Our Case Number: ABP-314724-22

Re: Railway (Metrolink - Estuary to Charlemont via Dublin Airport) Order [2022]
Metrolink. Estuary through Swords, Dublin Airport, Ballymun, Glasnevin and City Centre to
Charlemont, Co. Dublin

**RE: SUBMISSION ON THE METROLINK RAILWAY ORDER APPLICATION IN
RELATION TO THE SITE OF A COMMERCIAL DEVELOPMENT AT 2 GRAND
PARADE, RANELAGH, DUBLIN 6.**

AN BORD PLEANÁLA REFERENCE: ABP-314724-22

Client	TII NTA	Project	METROLINK	Drawing Title	METROLINK - STRUCTURES CHARLEMONT STATION PROPOSED STREET LEVEL DESIGN	Drawing Status	S0
Consultant	JACOBS IDOM	Drawing N°	ML1-JAI-SRD-ROUT_XX-DR-Z-02090	Plan Drawing N°	ML-ST 307 O-A1		
		Scales Original Size A1	1:250			Sheet	1 of 6

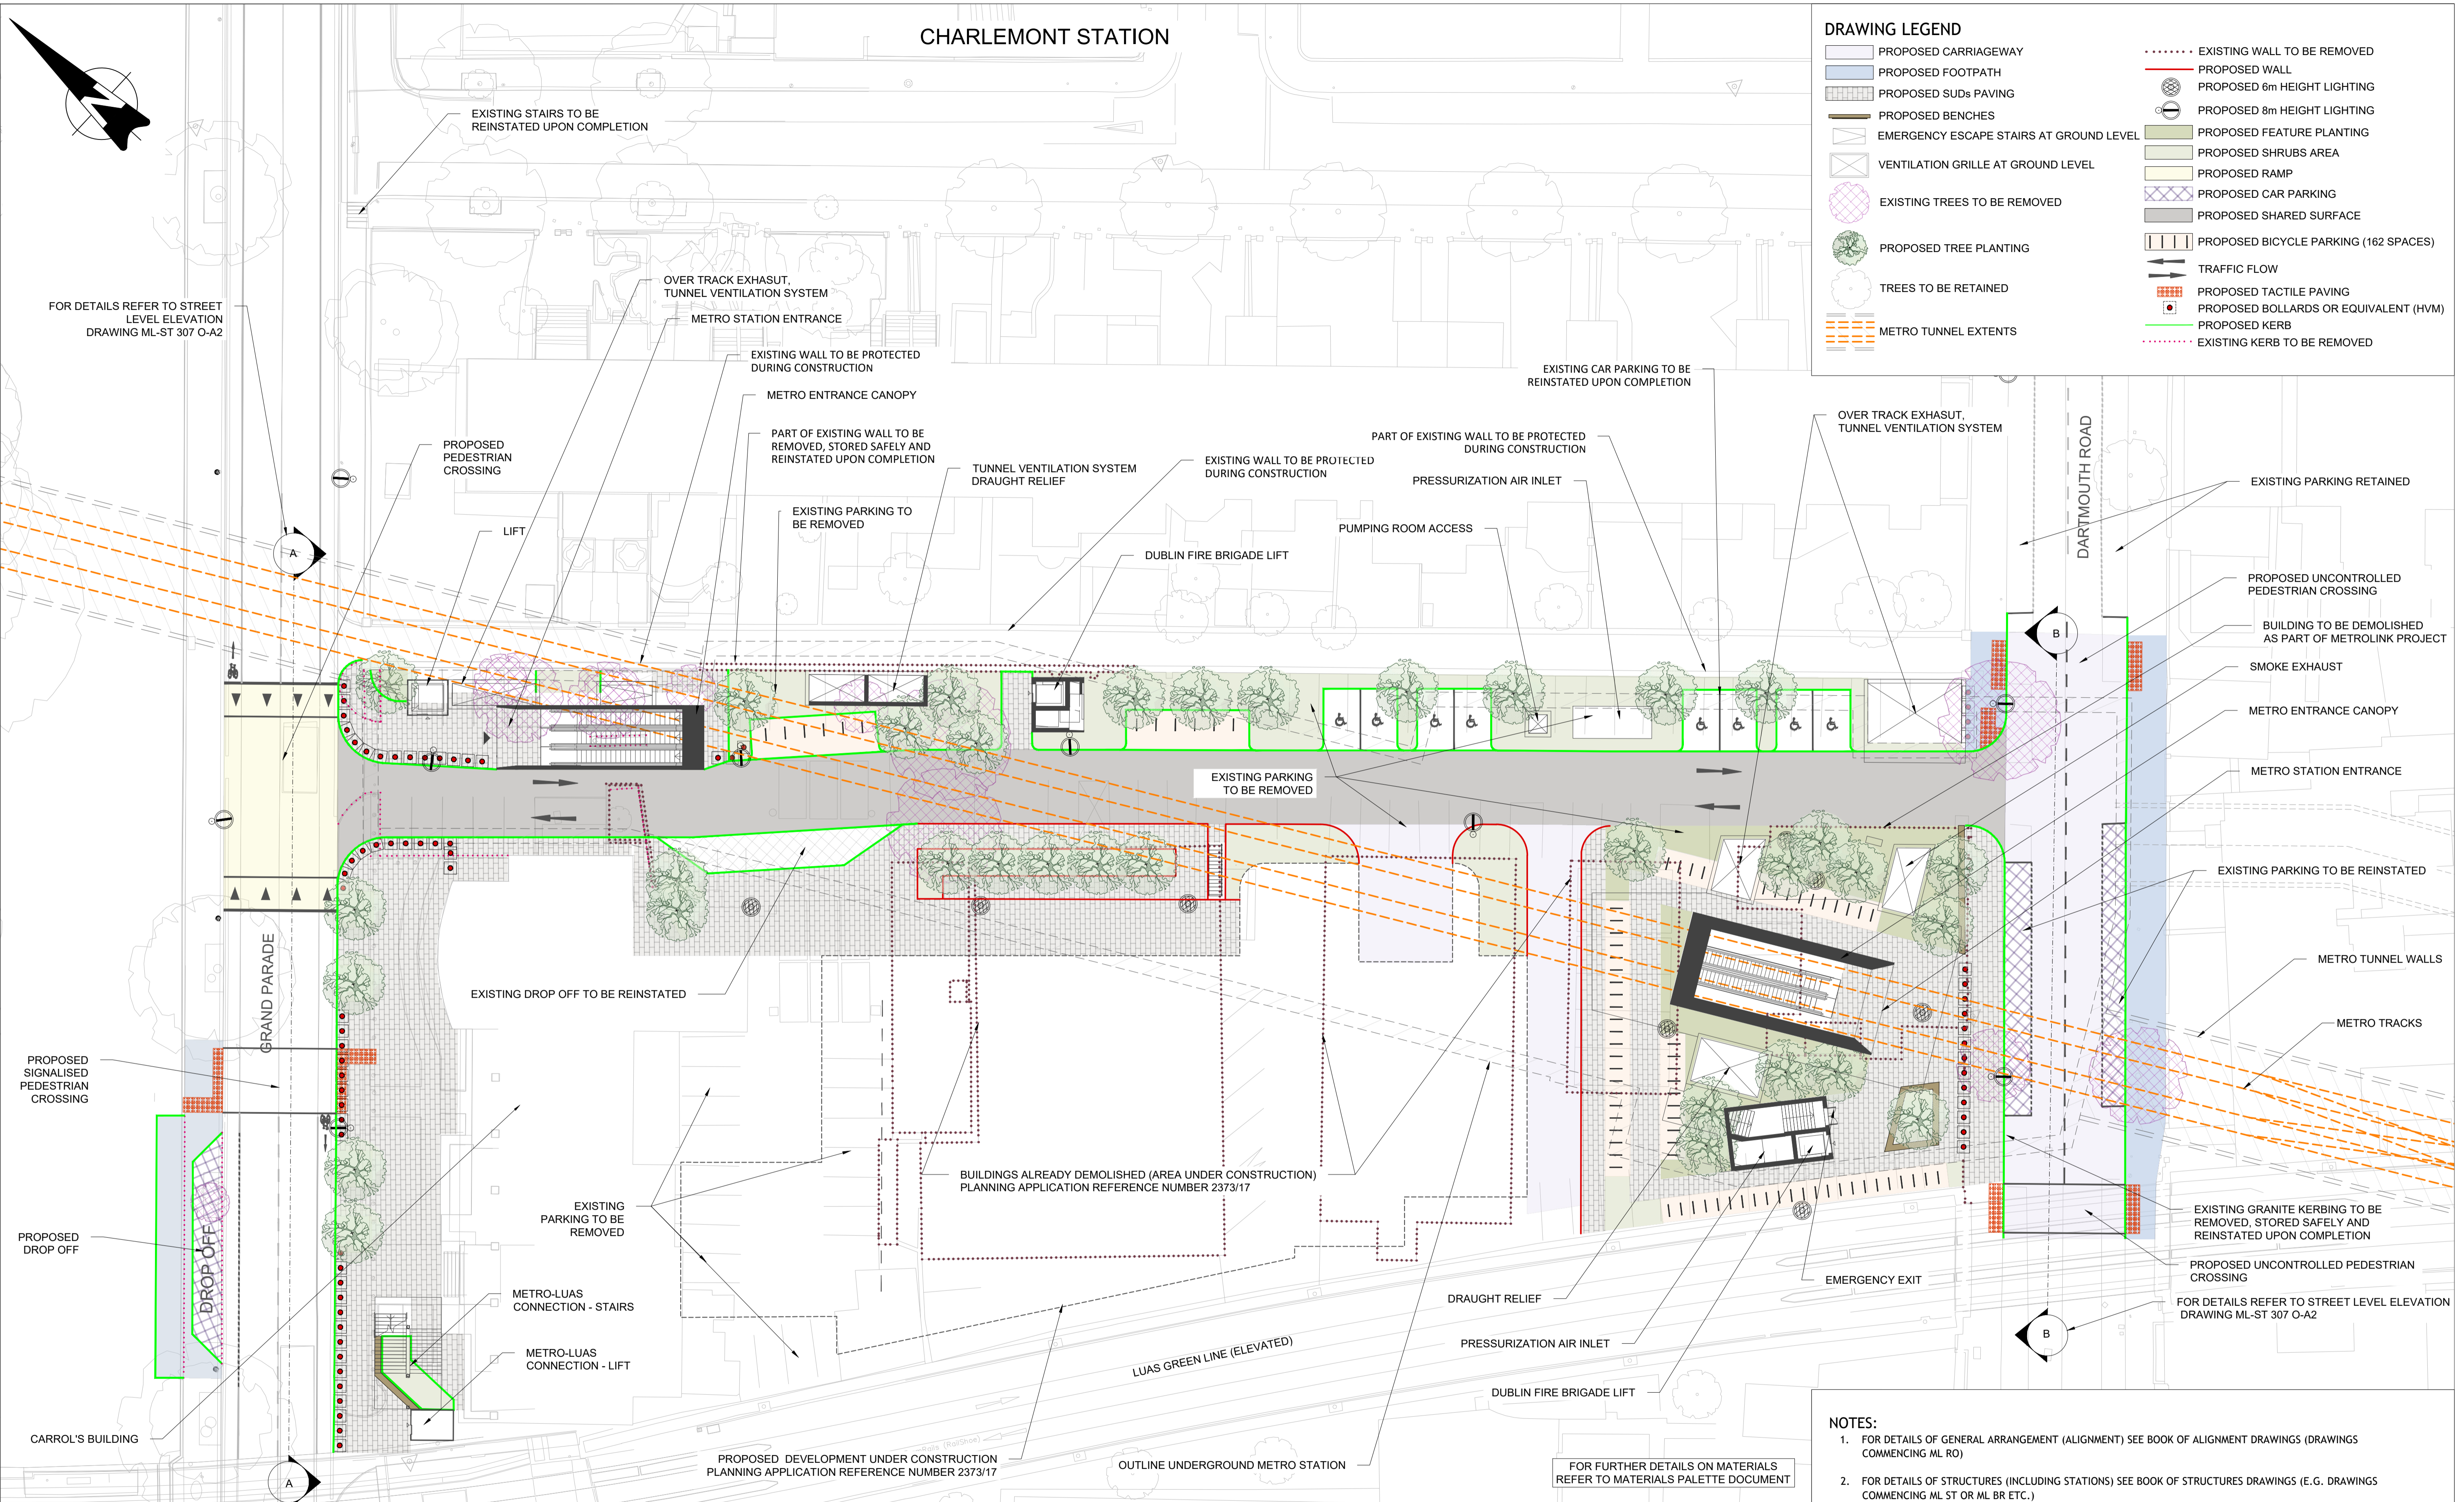
The revised drawings also include an updated street level design layout at Charlemont / 2 Grand Parade (Drawing No. ML1-JAI-SRD-ROUT_XX-DR-Z-02090). This layout reflects the reinstatement of 14 no. car parking spaces associated with no. 2 Grand Parade following completion of the works. This revision in the parking arrangement is welcomed by our client.

As noted in the original submission on the RO application and in submissions to the Oral Hearing, it is proposed to provide a Metro-Luas connection lift and stair to the northwest of the Carrolls Building within the 2 Grand Parade site.

- The structure would obstruct designated fire escape routes from the 2 Grand Parade development.
- There would be an additional risk of fire spread in the event of a fire due to proximity to the existing building.
- Additional information needed in relation to pedestrian traffic flow and capacity for both normal and evacuation scenarios.
- The stairway and lift shaft will negatively impact on the appearance and setting of the Carroll's Building, a protected structure which is integrated into the 2 Grand Parade commercial development.
- The stairway and lift could give rise to privacy issues within the adjacent office building.

The design and location of this stairs and lift remains unacceptable to our client, and it is requested that revisions are made to this aspect of the design prior to the granting of any Railway Order, by condition or otherwise.

The updated information submitted to the Oral Hearing by TII included revised drawings, schematics, and visualisations of the proposed lift and staircase. It is considered that these details further illustrate the conflict between the design of this connection and the existing protected structure on site, which features extensive glazing that would be directly adjacent to the proposed public stairway and lift.

It is respectfully submitted that the provision of both a lift and staircase at this location cannot adequately achieve both an acceptable level of visual impact on the protected structure and its front setting (which has been restored as part of refurbishment works to include upgraded landscape treatment and the restoration of water features), while also ensuring that there is not a significant impact on the privacy of the building. The design proposals indicated in the updated drawings and imagery submitted to the Hearing indicate glass balustrades on the

stairway, with pedestrians traversing the stairs within c. 1-2 metres of work spaces within the building.

At the Oral Hearing, an alternative design proposal was put forward by Henry J Lyons Architects, involving the relocation of the proposed lift shaft to the opposite side of Grand Parade, adjacent to the drop-off location for persons with restricted mobility which was introduced at Oral Hearing stage.

It is submitted that this alternative would strike a more appropriate balance, allowing the relocation of the stairway closer to the Luas embankment, reducing visual impact on 2 Grand Parade, and reducing privacy impact.

The alternate lift shaft location would be in closer proximity to the PRM drop-off and would be immediately visible from the MetroLink station exit adjacent to 2 Grand Parade. A level crossing is already proposed to provide a direct connection across Grand Parade at this point. The ecology assessment for the PRM drop off indicated that it would not give rise to any significant impact, and the installation of the lift shaft could be accommodated alongside the works for the PRM drop-off area.
